Your ref:
Our ref: 20/10855/PREP
Enquiries to: Mrs Caroline Evans
E-mail:
caroline.evans@eastriding.gov.uk
Telephone: (01482) 393732
Date: 20 October 2020

Proposal:	Proposed installation of new outdoor cricket net facility following the removal of the existing facility
Location:	Welton Cricket And Hockey Club, Stanley Jackson Way, Welton, East Riding Of Yorkshire, HU15 1PT,
Applicant:	Mr Howard Kingdom
Application Type:	Pre Application Planning Enquiry

Drawing Title PROPOSED SITE BLOCK PLAN & SITE PLAN Drawing Size A1

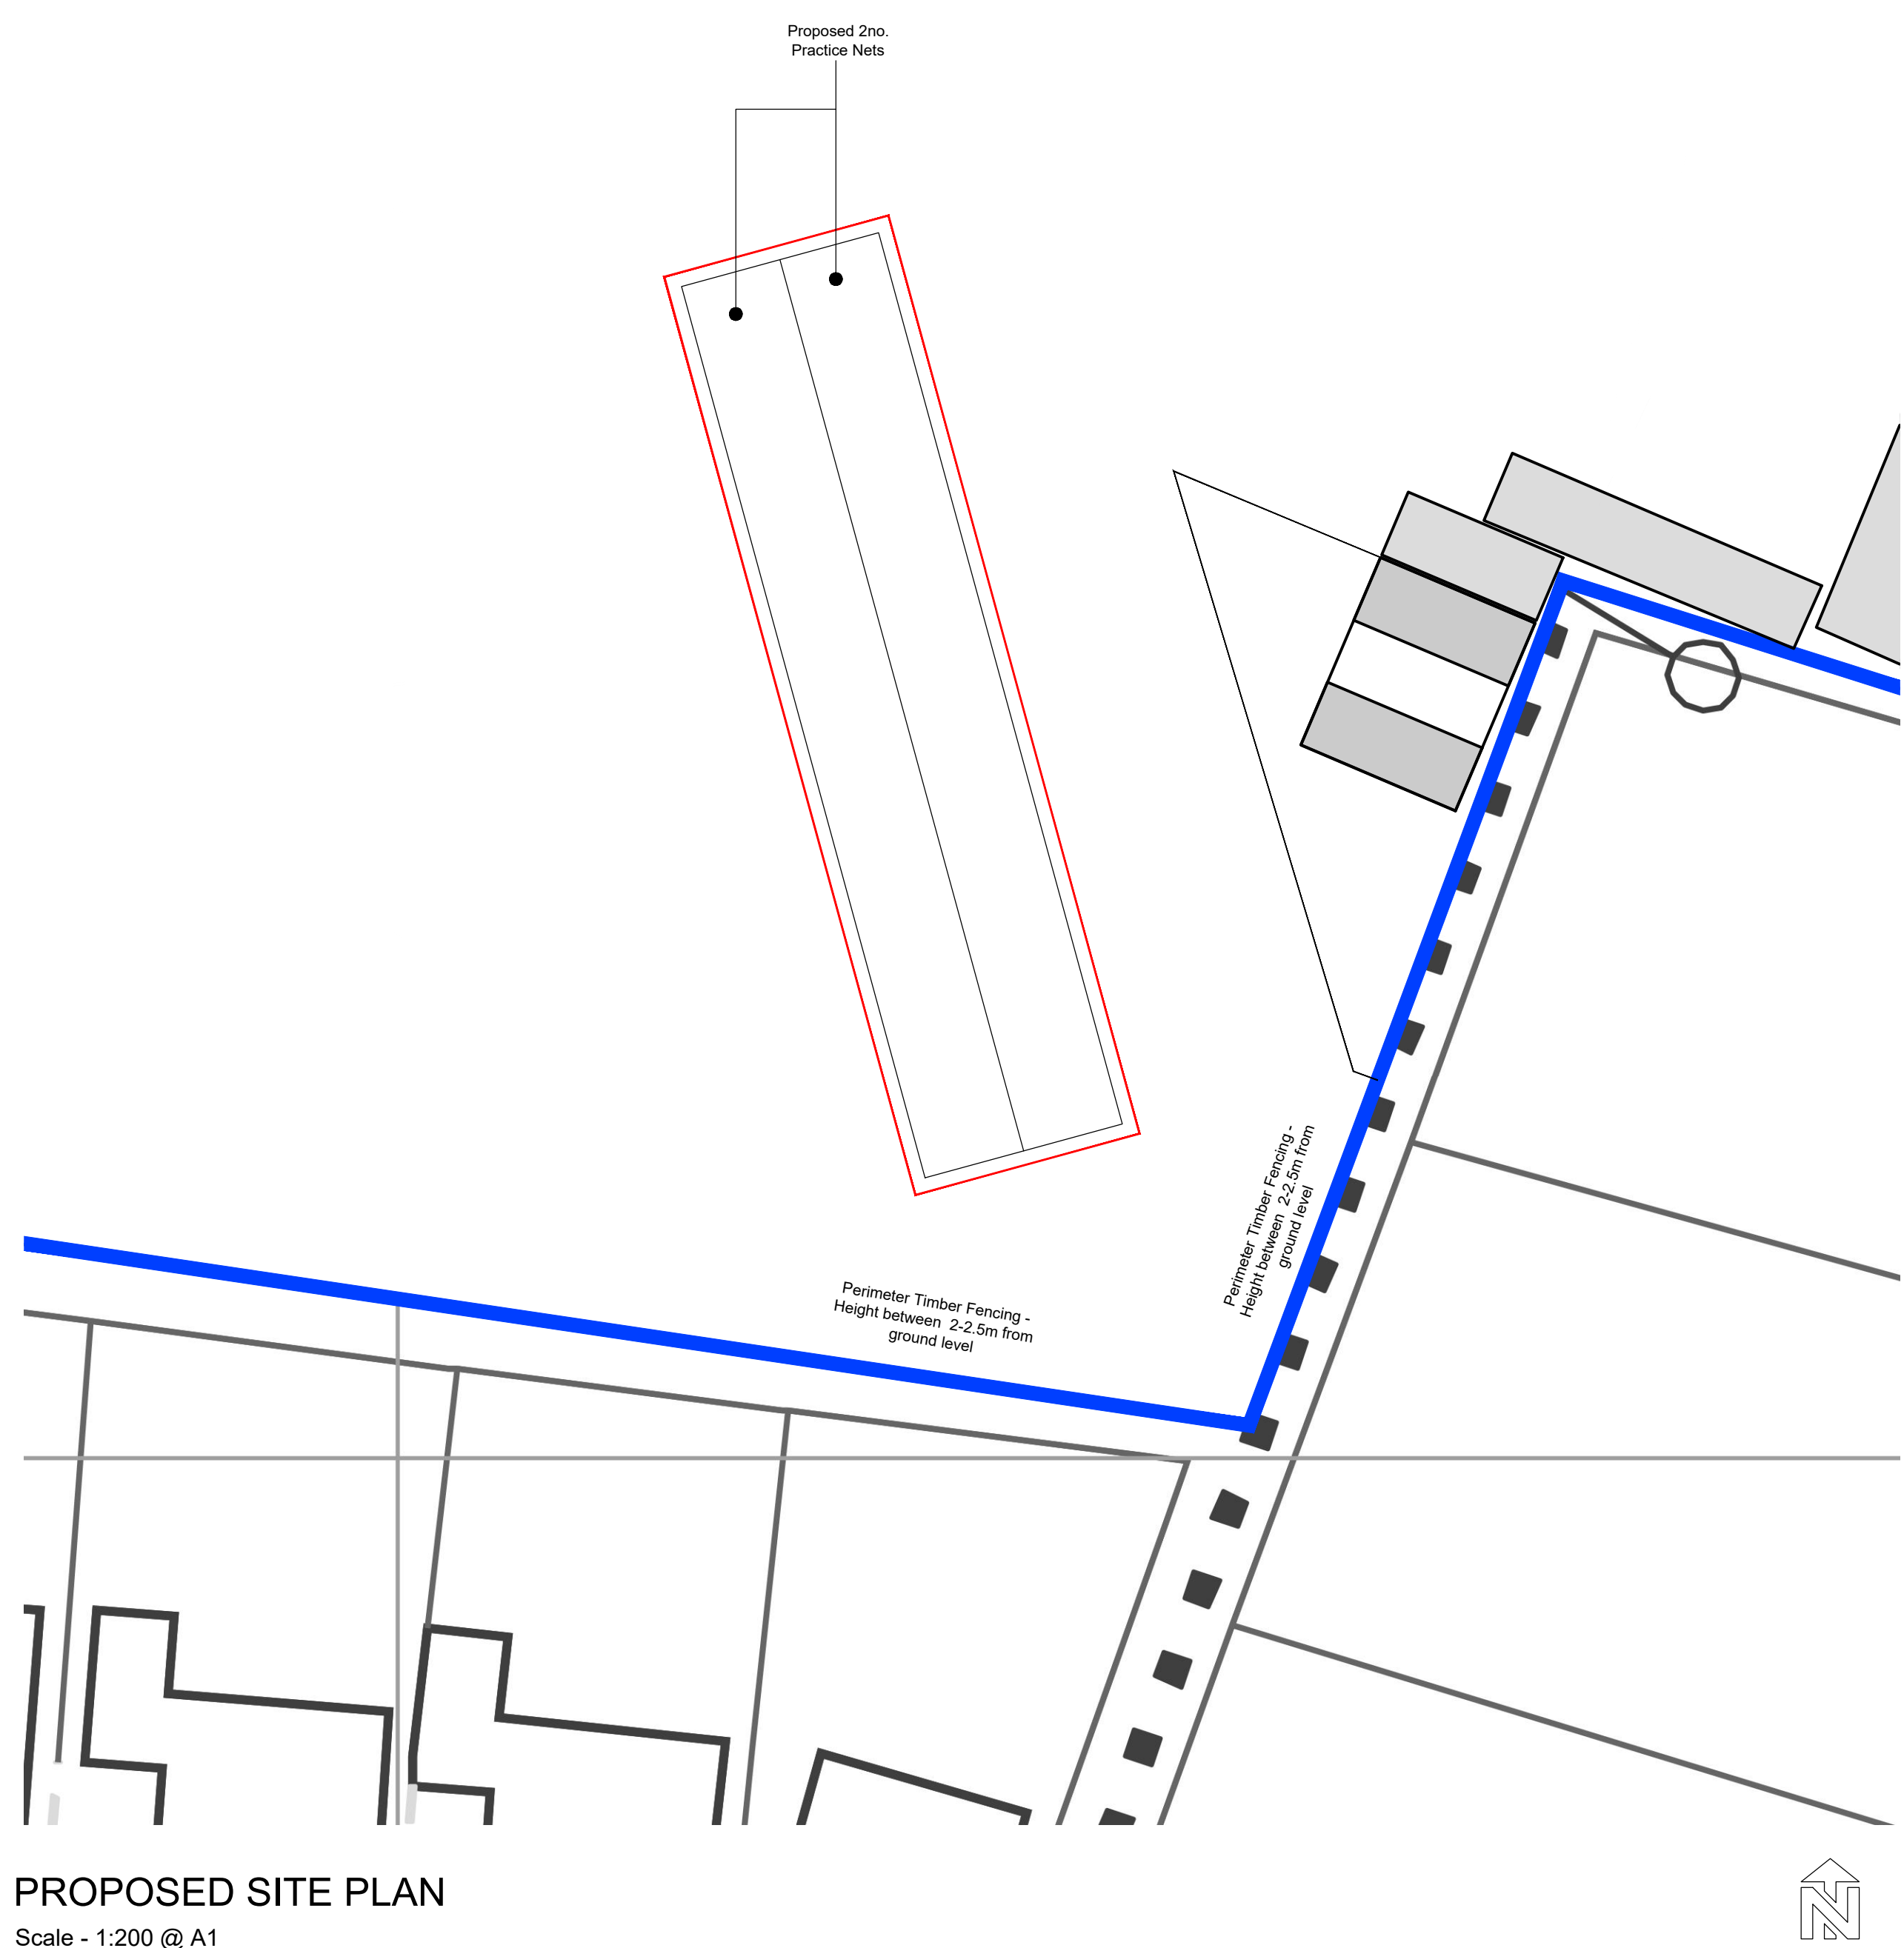
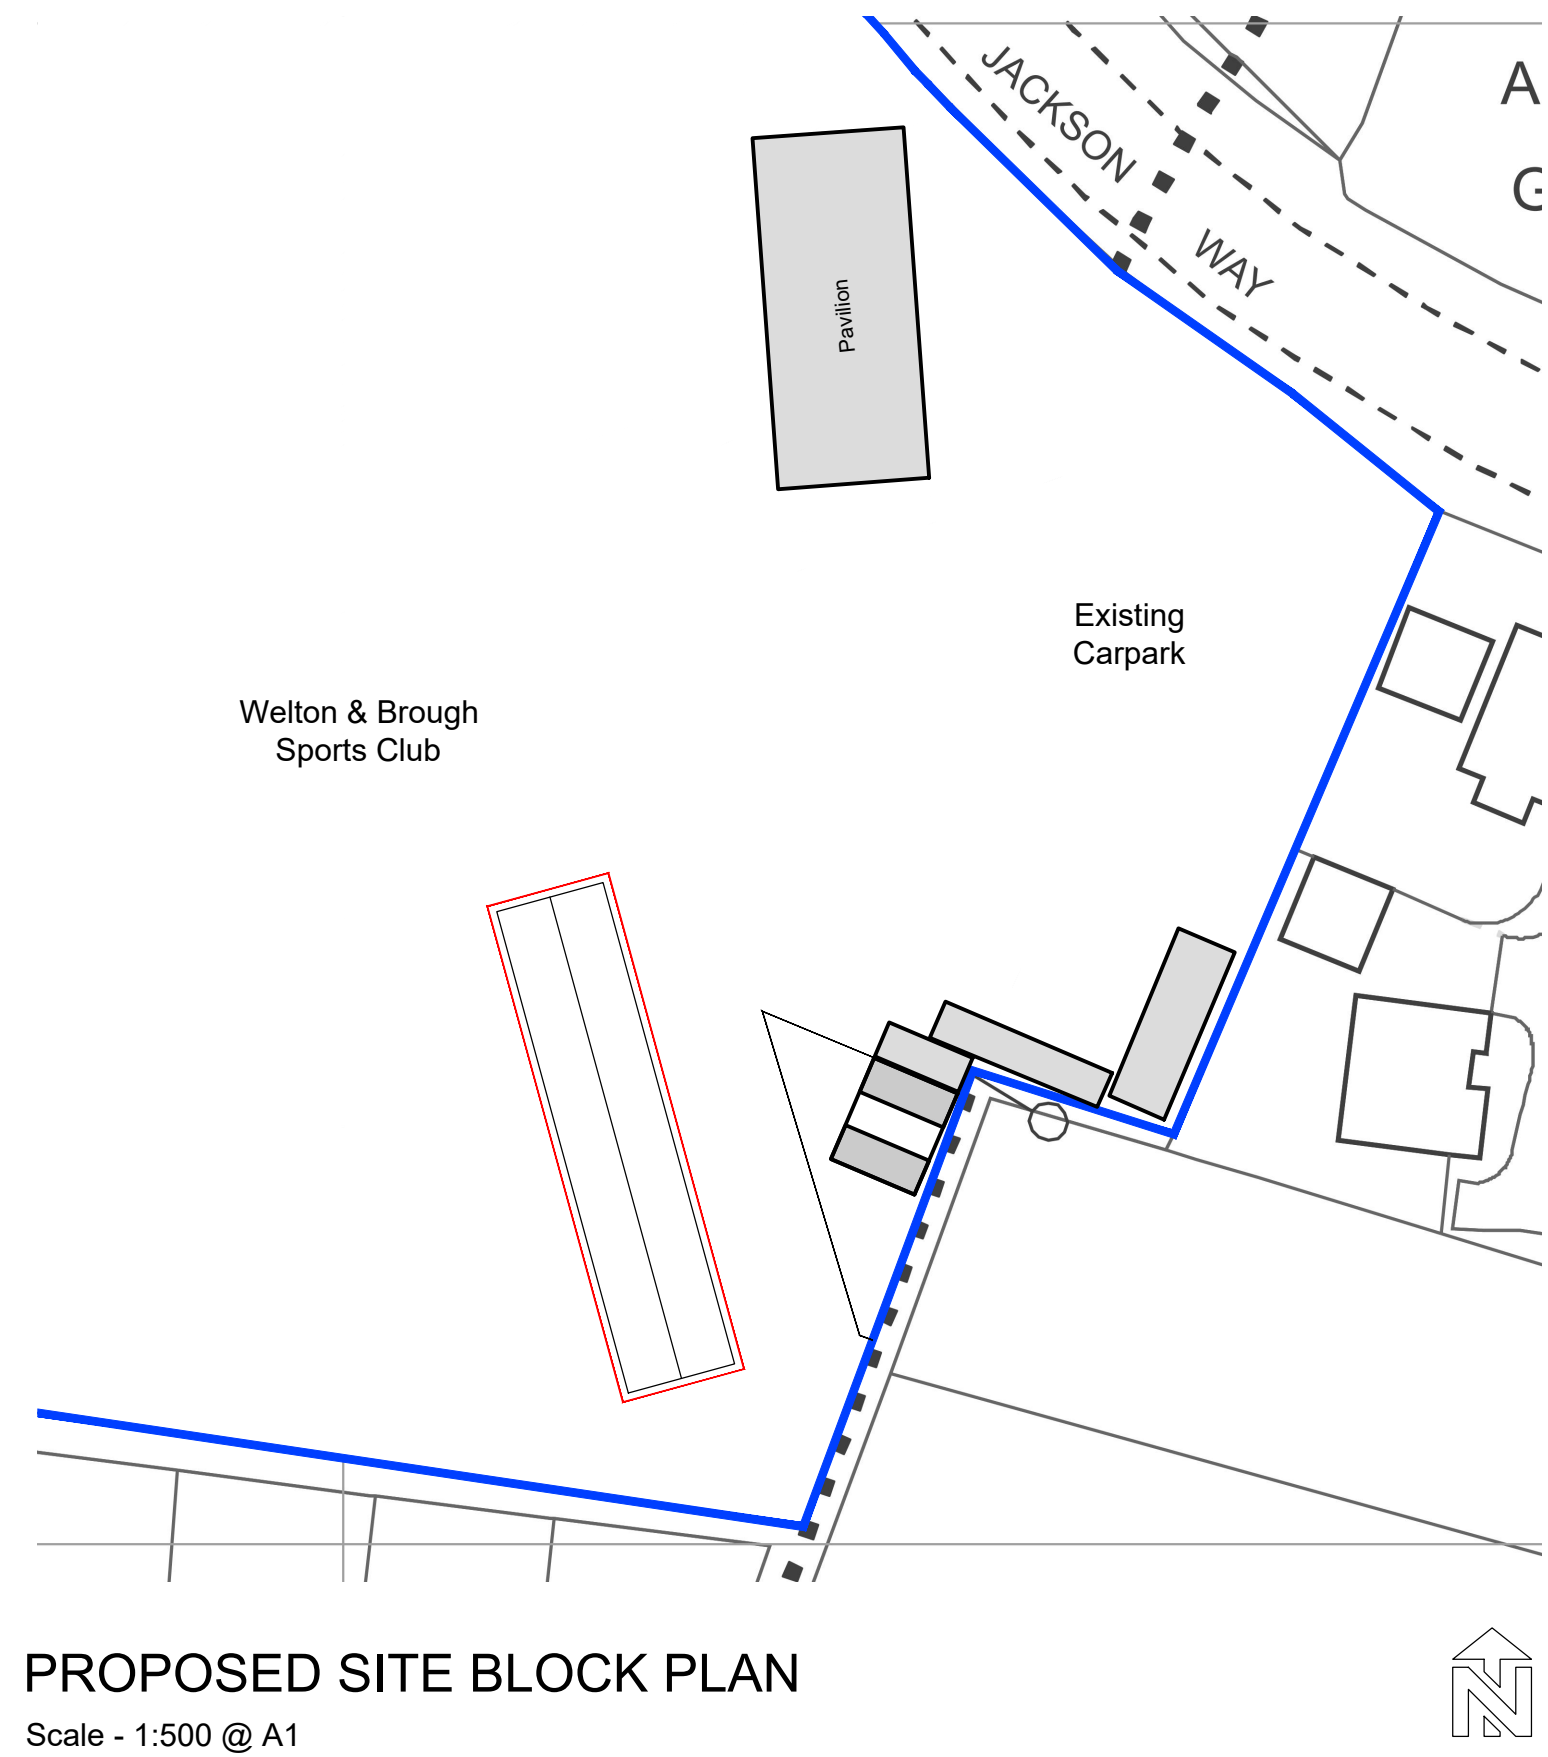
The proposed cricket nets would stand at 4m in height, covering an area of 240sqm on the site of an existing provision located at the southern corner of an existing cricket club outside of the development limit. There are neighbouring properties to the south and east, and the existing pavilion building lies to the north. The development would not impinge on the existing playing provision and would in fact improve the training facilities.

Whilst the site is outside of the development limit and also designated as Open Space, the proposed development would be associated with an existing sports facility and would replace existing equipment on the same footprint. It is therefore considered that the principle of the development would be acceptable in terms of policies S4 and C3 of the ERLP SD.

The proximity of the development to neighbouring properties is unlikely to significantly increase impact on residential amenity from noise disturbance given that the new facility would be constructed on the existing footprint. The site is not within a flood zone but consideration should be given the construction of the new surface to ensure that there is adequate drainage.

The position of the development would not adversely impact on the wider area character of the surrounding landscape and would in fact improve the appearance of the sport field given that the existing facility was untidy.
